**RE: Response Letter to the Review Comments dated February 10, 2020 – O'Reilly Auto Parts,
Colorado Springs, CO.**

Please find below the responses to the Review Comments for the proposed O'Reilly Auto Parts
in Colorado Springs, CO.

1 ADA ROUTE PLAN
C2.4 SCALE: 1" = 20'-0"

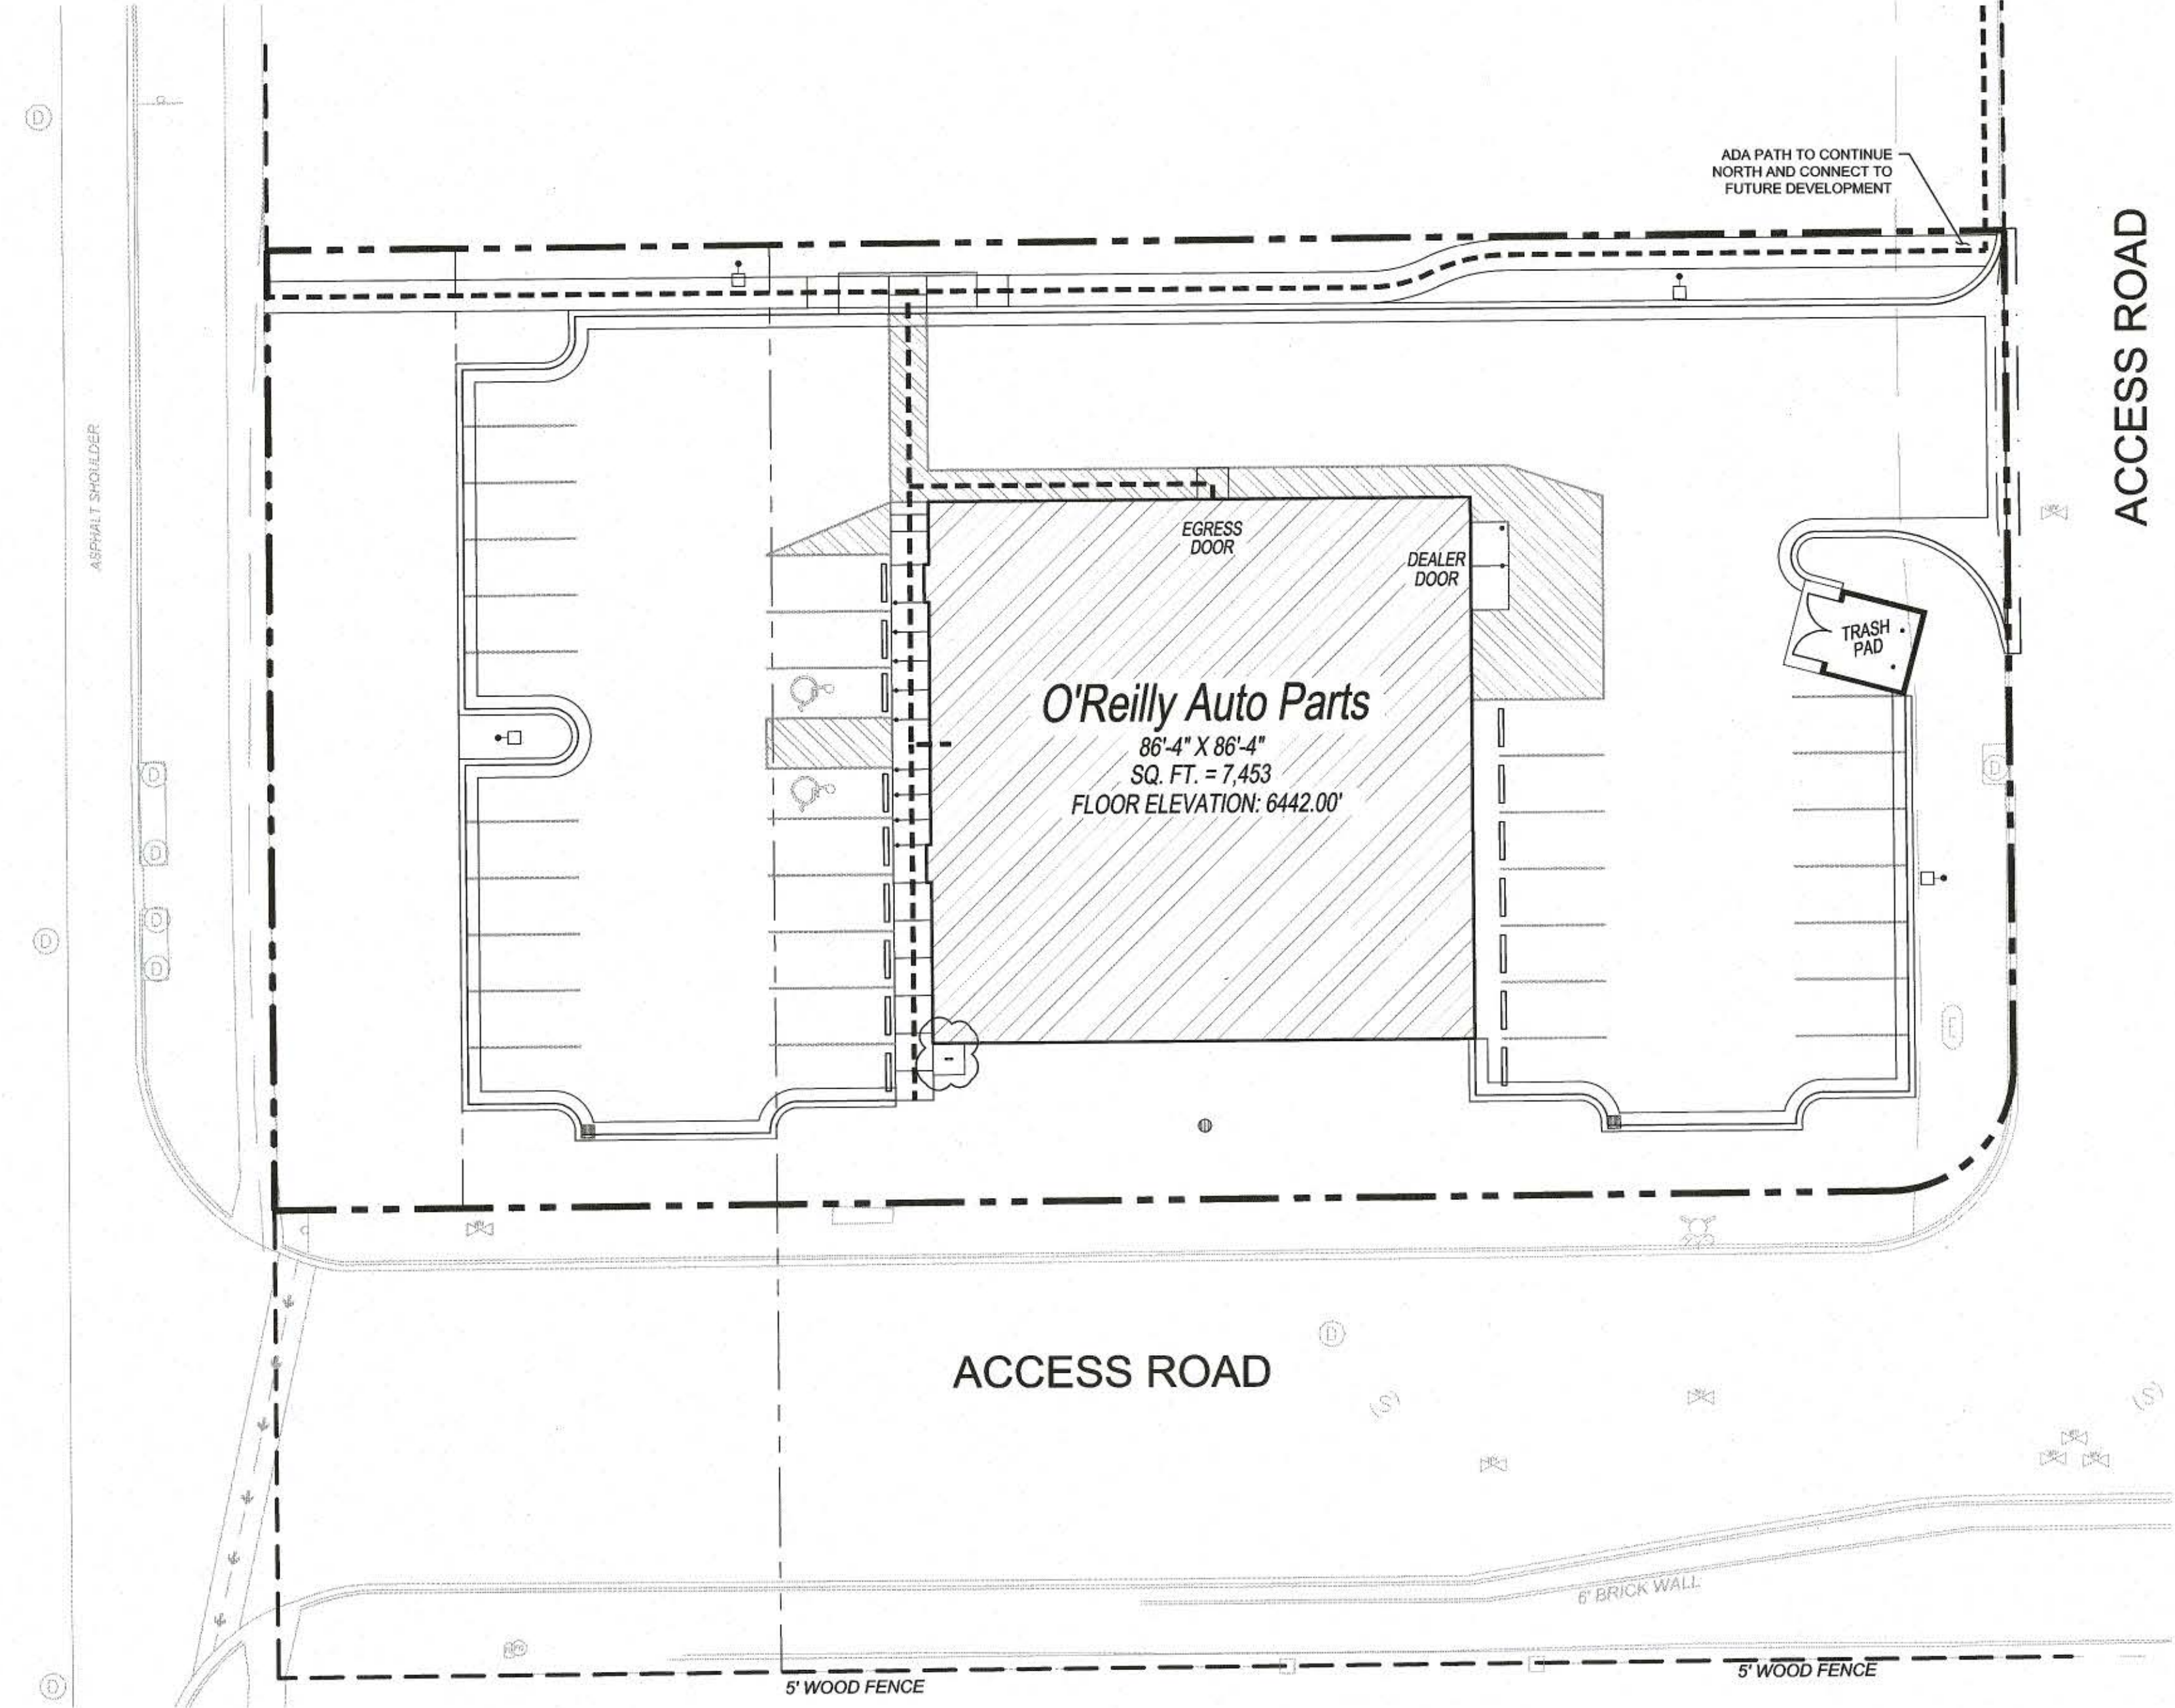
2. Also required is an additional page illustrating the ADA route.

Response: The ADA Route Plan was included in the previous submittal. It is Sheet C2.4 ADA Route Plan.

**1 SITE UTILITY PLAN**  
C3.1 SCALE: 1" = 20'-0"

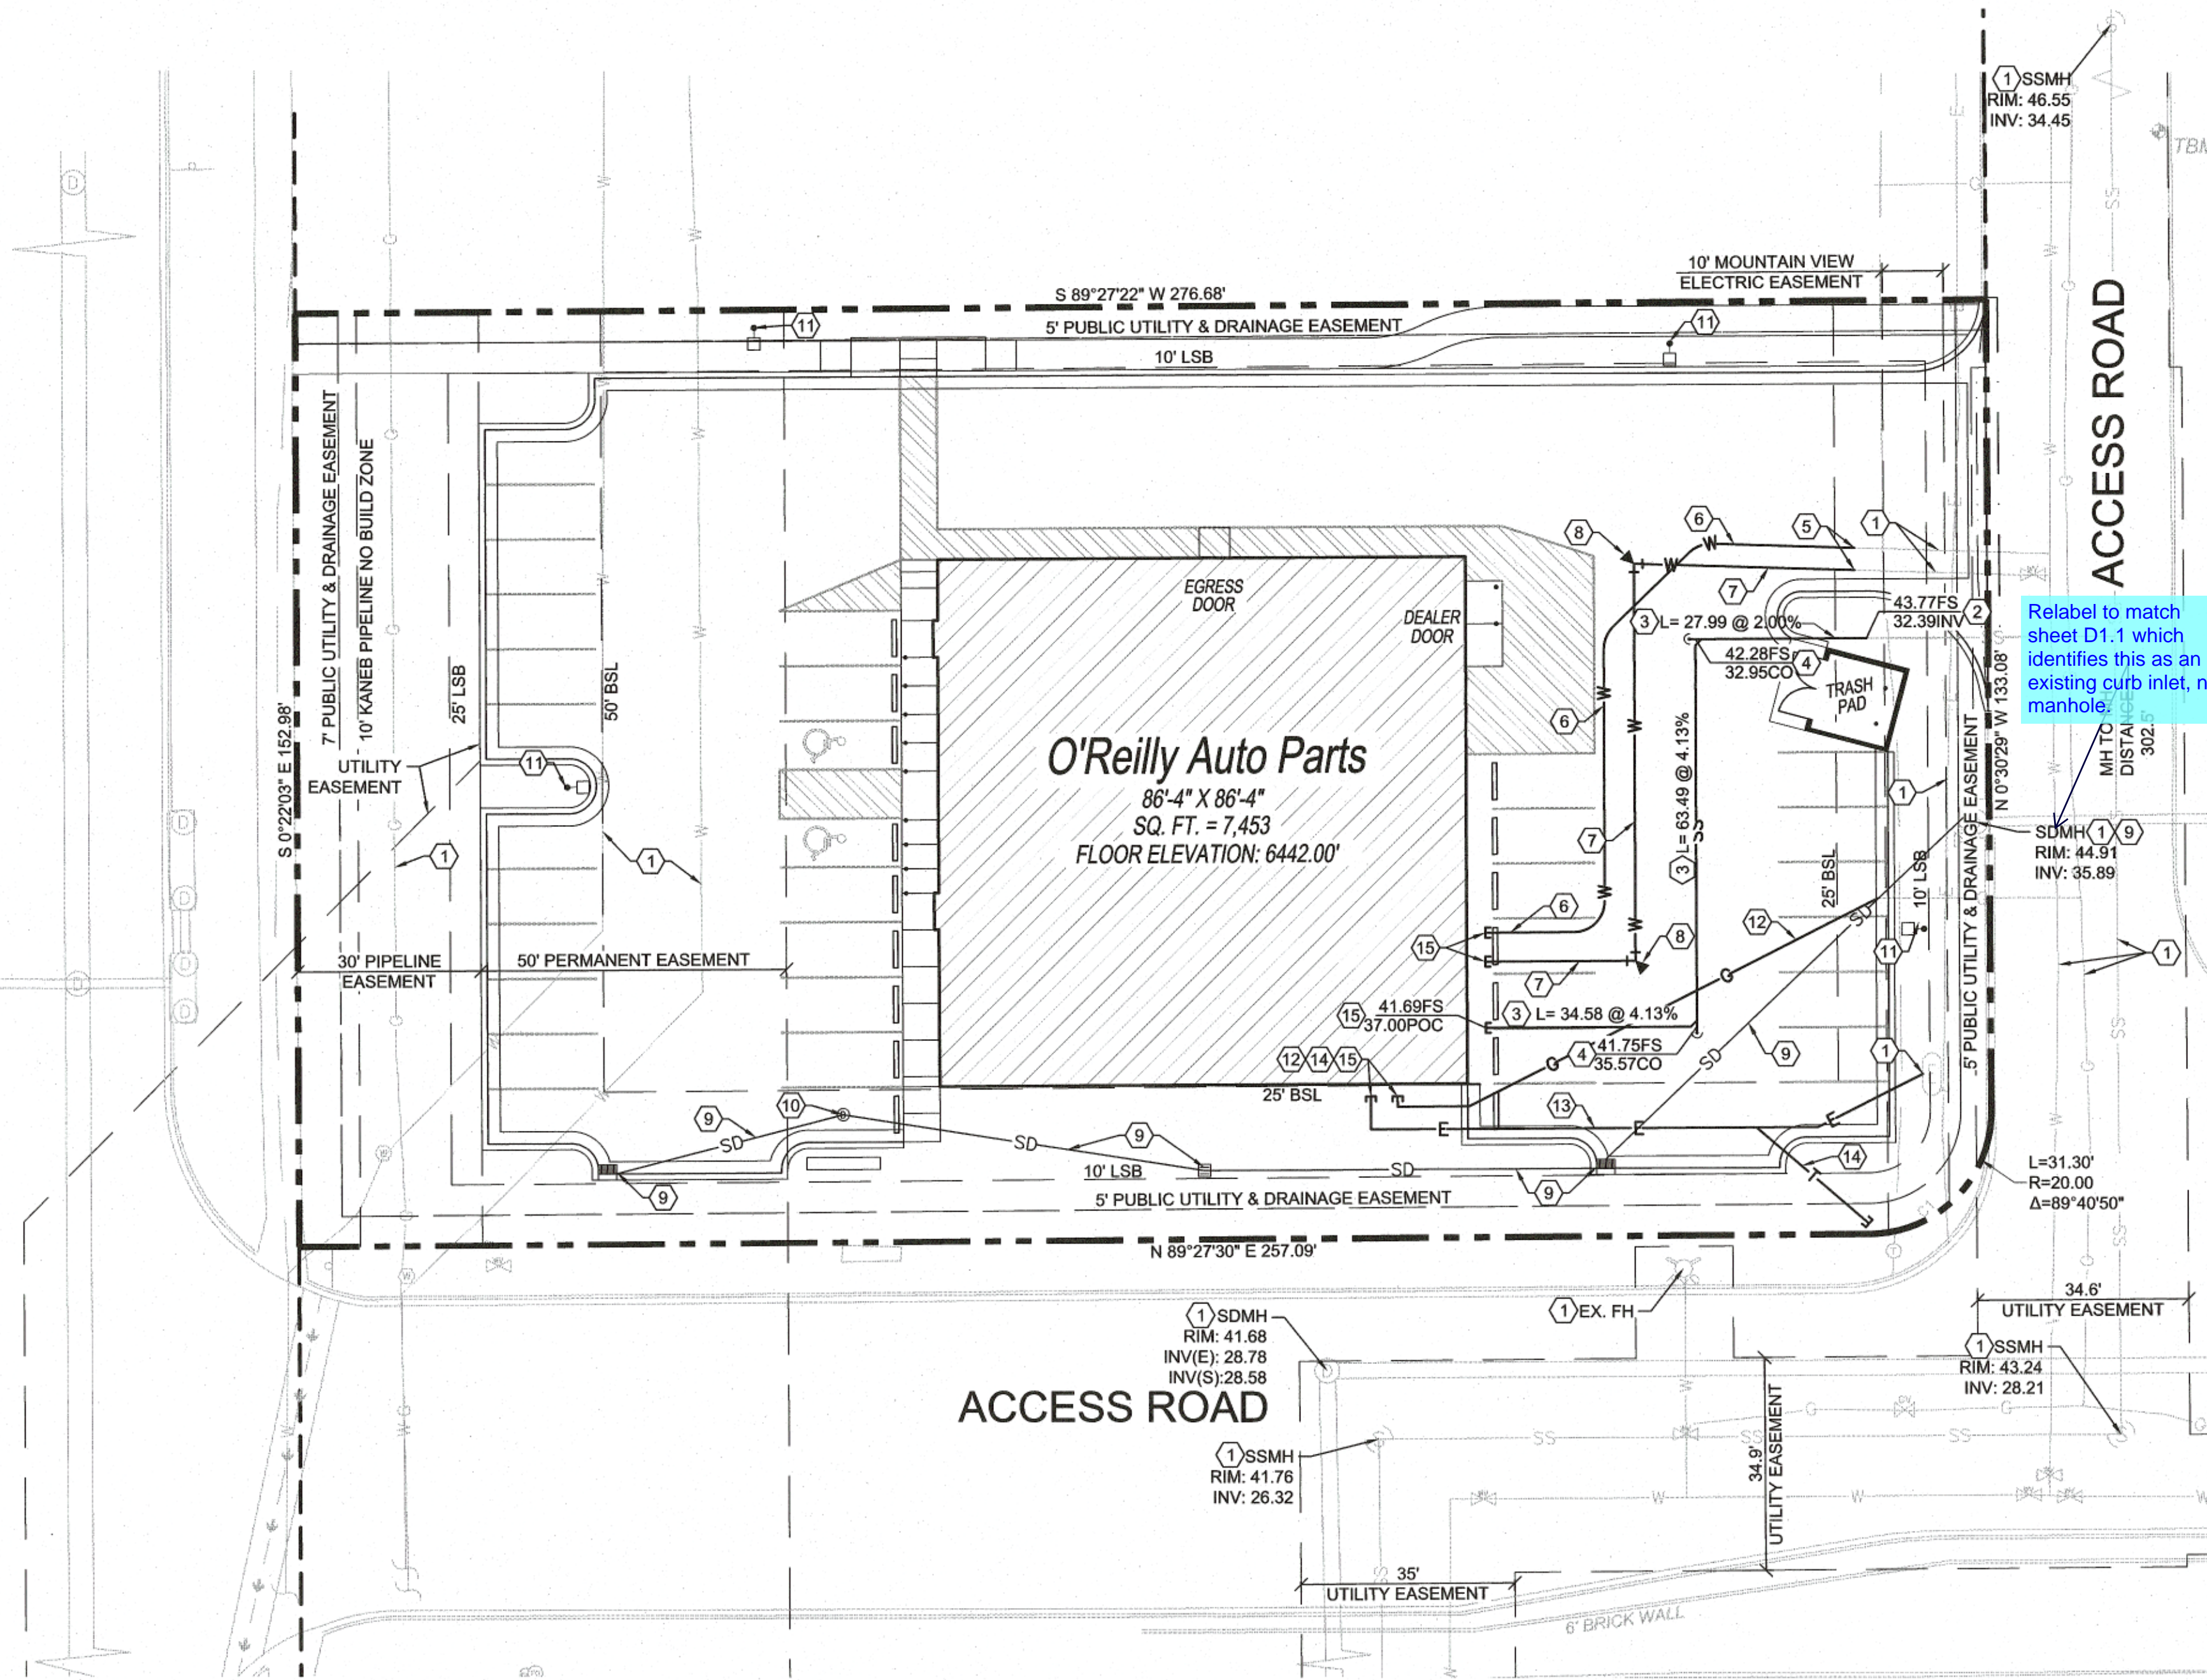
1. Relabel to match sheet D1.1 which identifies this as an existing curb inlet, not manhole.

Response: Sheet C3.1 has been updated to identify the structure as an existing curb inlet.
